Submission made by Highways England pursuant to Deadline 5 of the Examination of the A30 Chiverton to Carland Cross scheme

Appendix A: Overview of changes made to Land Plans, Works Plans, Rights of Way and Access Plans, General Arrangement and Section Plans, Environmental Masterplans

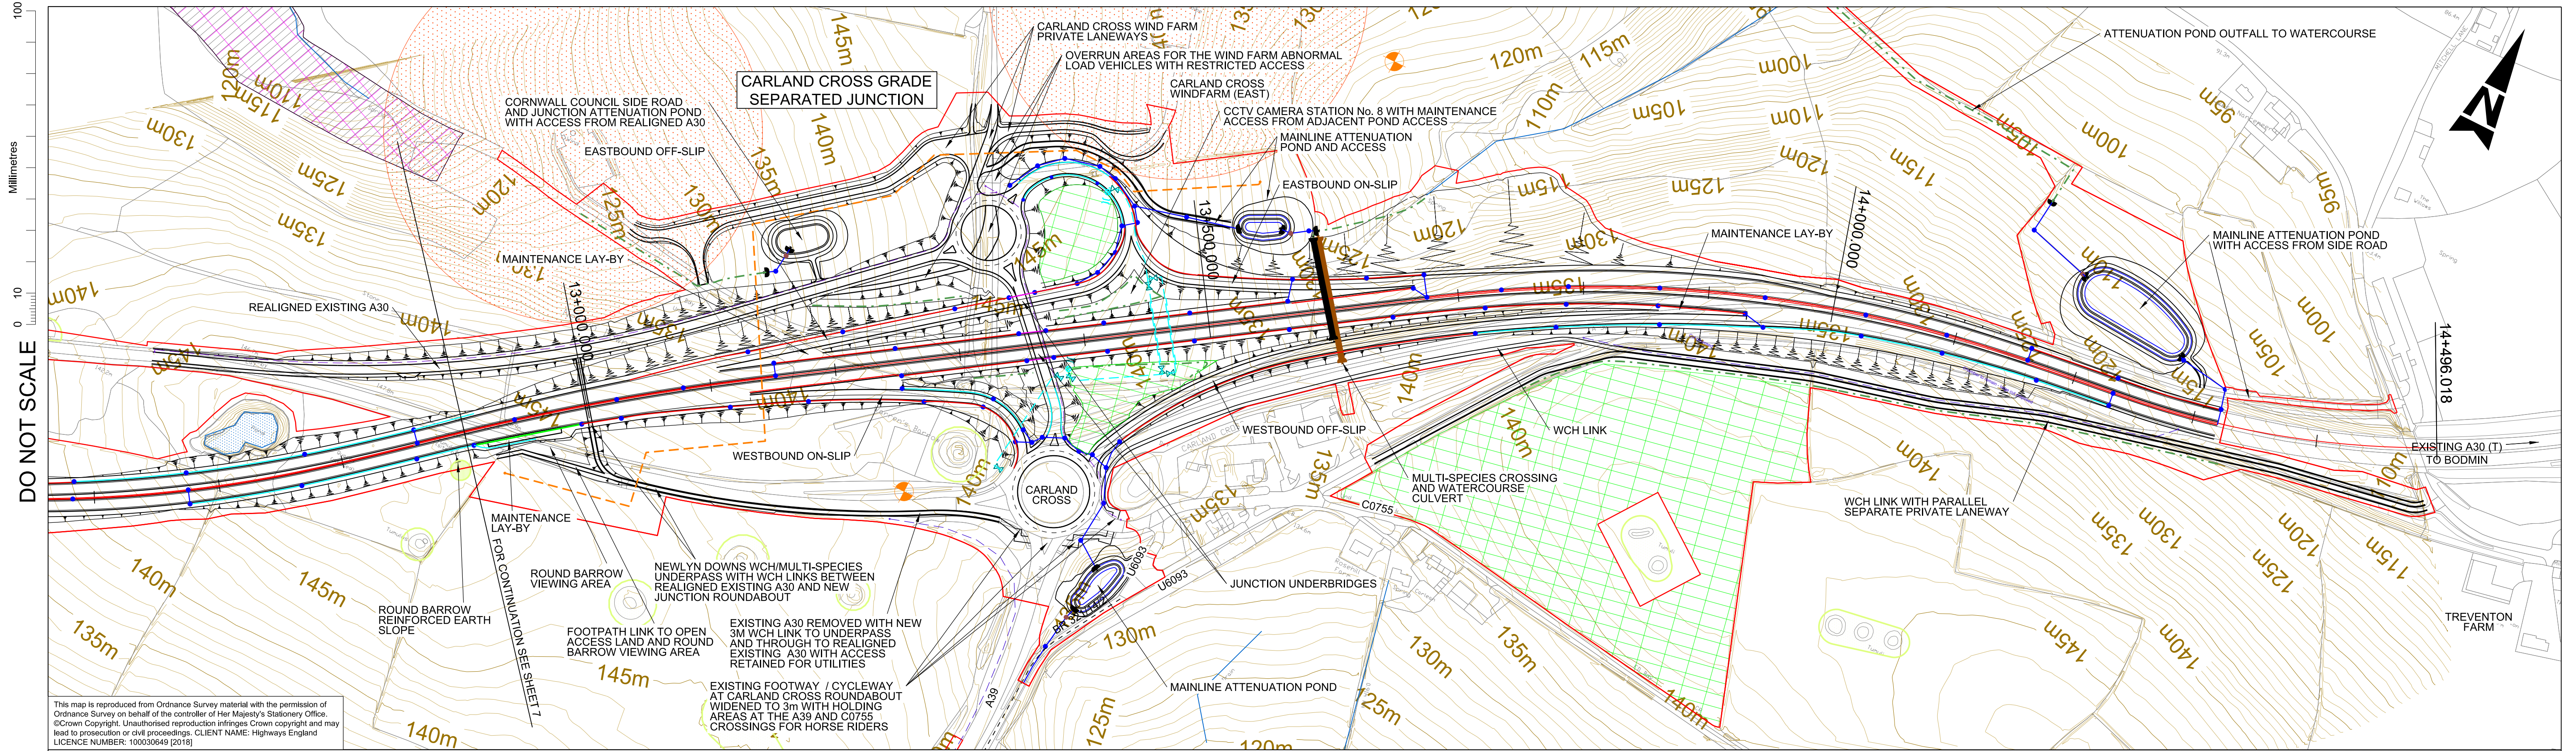
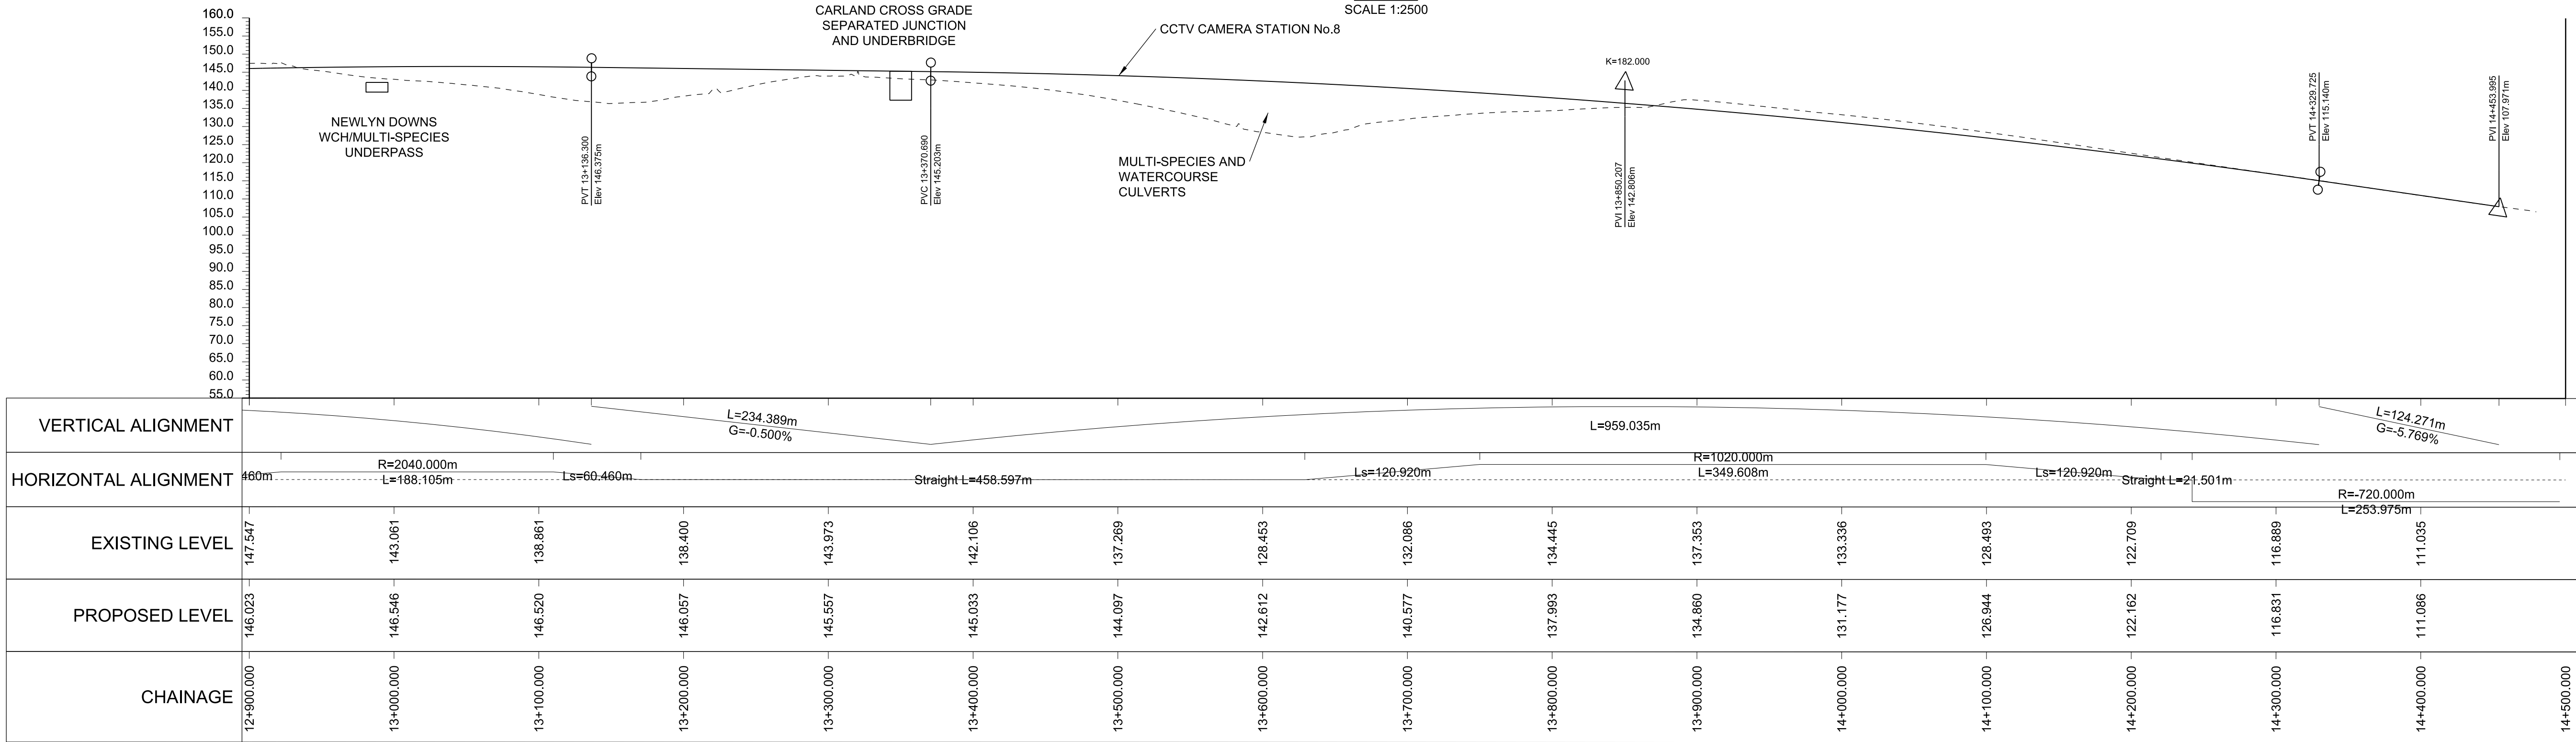
Sheet 3	Amended roundabout with abnormal vehicle overrun area and addition of label for overrun area.
Sheet 8	Amended layout to suit new access west of existing Carland Cross roundabout.

Amended layout to suit realigned Bridleway and addition of WCH label.
Environmental Masterplans (Document Reference 6.3, Figure 7.6(B))	
Sheet 18	<p>Addition of the Elevated Viewing Area and Footpath west of the existing Carland Cross roundabout.</p> <p>Amendment to show Carland Cross roundabout overrun for SPR.</p>
Sheet 19	<p>Amended layout to show realigned Bridleway VV.</p> <p>Amendment to show Carland Cross roundabout overrun for SPR.</p>
